**WEST SUSSEX COUNTY COUNCIL
PLANNING SERVICES CONSULTATION**

SUBJECT: LU/320/17/PL -Alterations to golf practice ground & surrounding land, including tees (incorporating importation of material).

Littlehampton Golf Club, Rope Walk, Littlehampton, BN17 5DL

Figure 4.1: Proposed access route and indicative location of suspension of parking bays

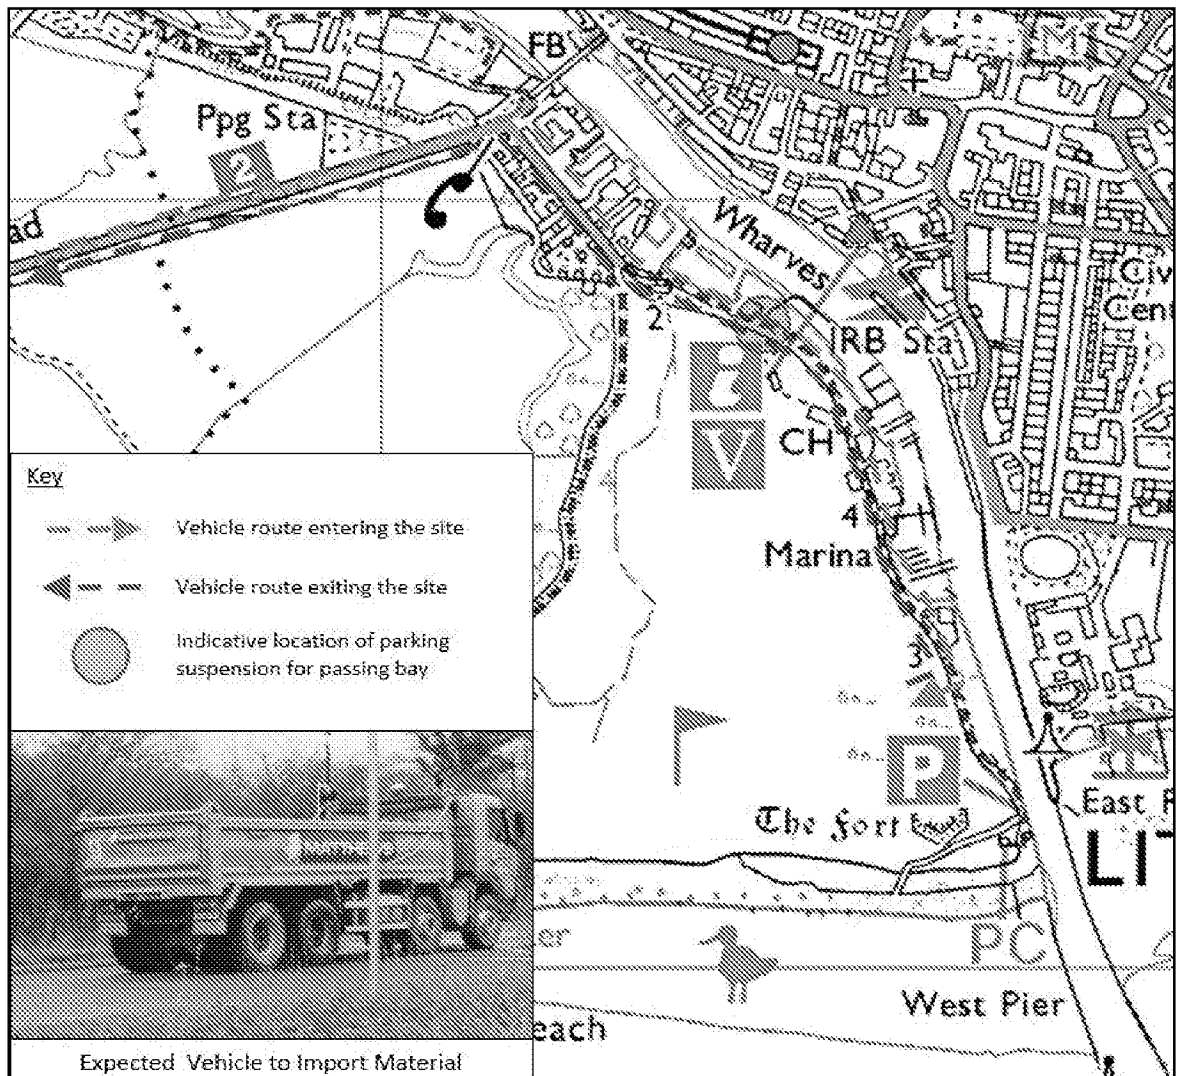
Another application (LU/208/17) has been submitted and approved for other works to be done at the Golf course with a traffic movement of 15 HGV's per day. If both applications were to start at the same time this would equate to 34 HGV movements per day. As part of these proposals it was proposed to widen the emergency/maintenance access. This application includes widening so that HGVs can still enter and egress the site. Swept path diagrams have been provided showing tipper movements; these are very restricted and will need the addition of a banksman to assist the driver getting into the site.

Within the TS it is stated that a CMP will be submitted post planning approval, however the LHA would request that information is provided pre-planning consent that this gives an indication of how deliveries will be managed. Within the application there is no traffic management in place to assist any HGV movement via ferry road, Ropewalk or the narrow West beach road leading to the golf course. This needs to be considered as well as the immediate movements within the vicinity of the site.
